Phone: 0300 123 6780
Email: developeras@lancashire.gov.uk
Your ref: 03.2023.595
Our ref: 03.2023.595
Date: 11.10.2023

Planning Application No: 3/2023/0595

Proposal: Convert the existing garage into living accommodation, including addition of monopitch roof.

Location: 12 Calder Avenue Billington BB7 9NQ

Outline of neighbouring property

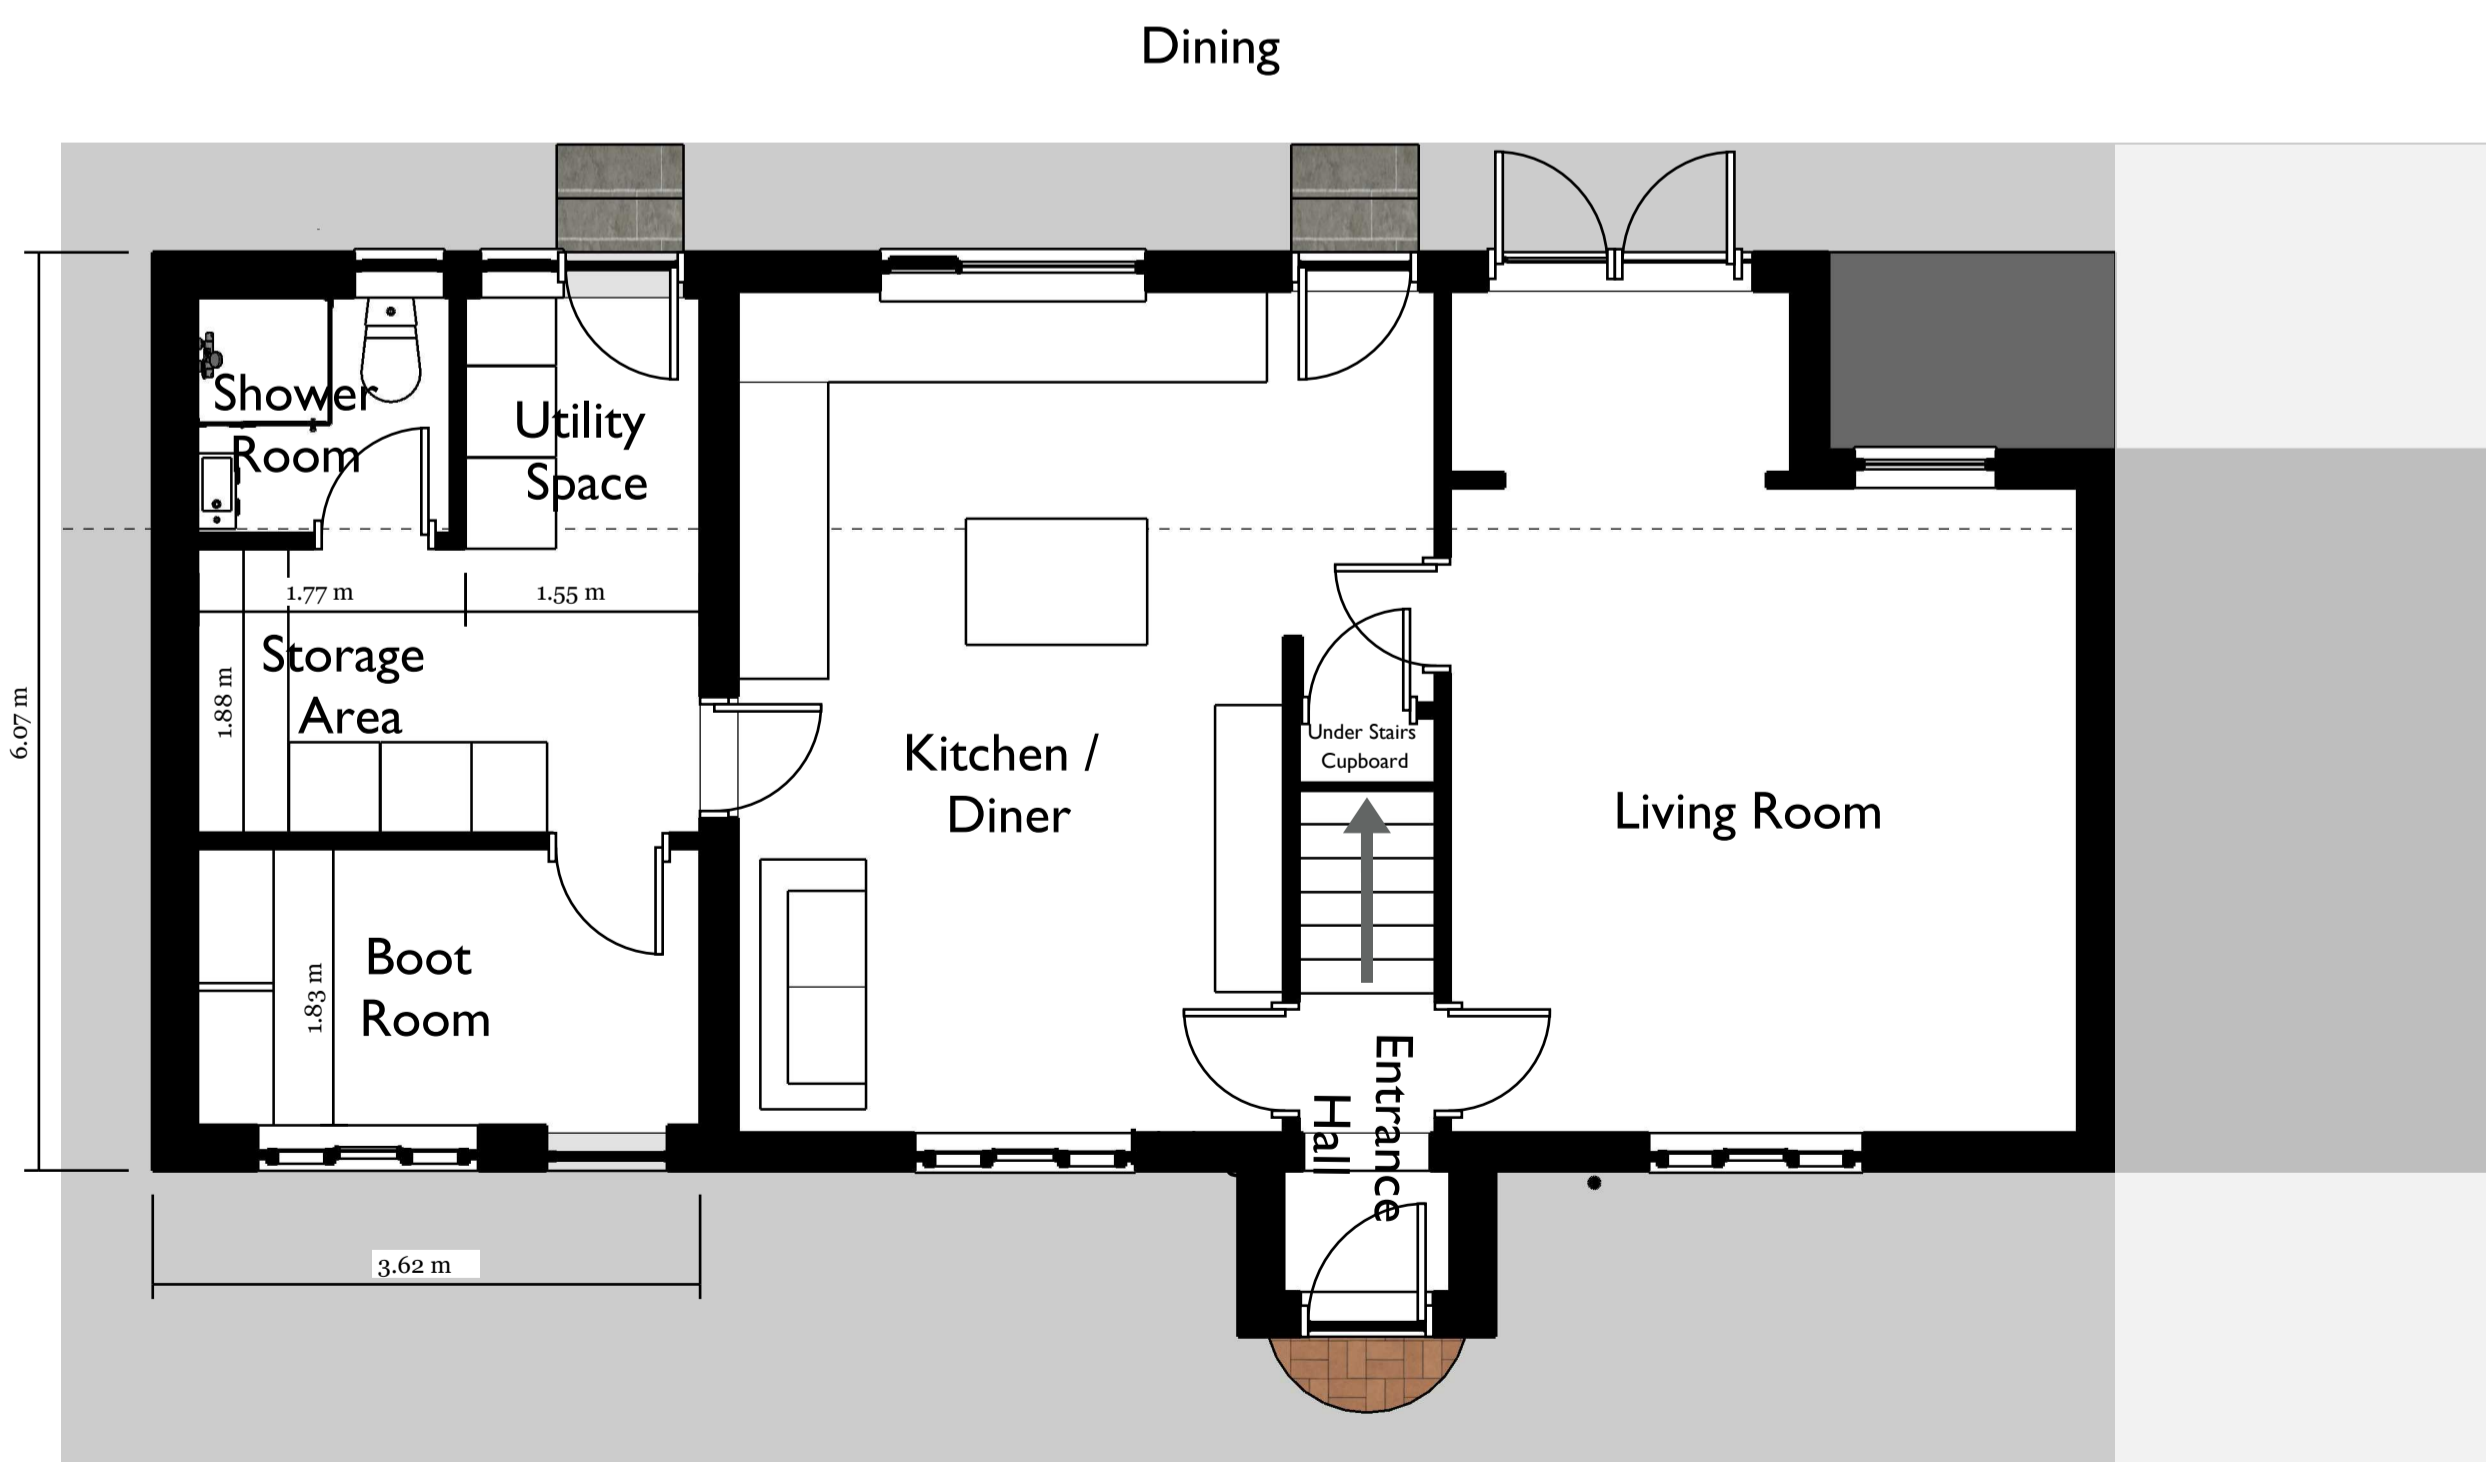
There is a loss of a parking space with this proposal. Providing 2 parking spaces can be provided within the curtilage as required by parking standards for this size of proposal then there is no objection to the proposal. The highway authority is of the opinion that the proposed development will not have a significant impact on highway safety, capacity or amenity in the immediate vicinity of the site.

- The parking areas must be constructed of a bound porous material and created before first occupation up until the lifetime of the dwellings existing in their proposed state. Reason: To ensure that satisfactory parking is provided before the dwelling hereby permitted becomes operative.
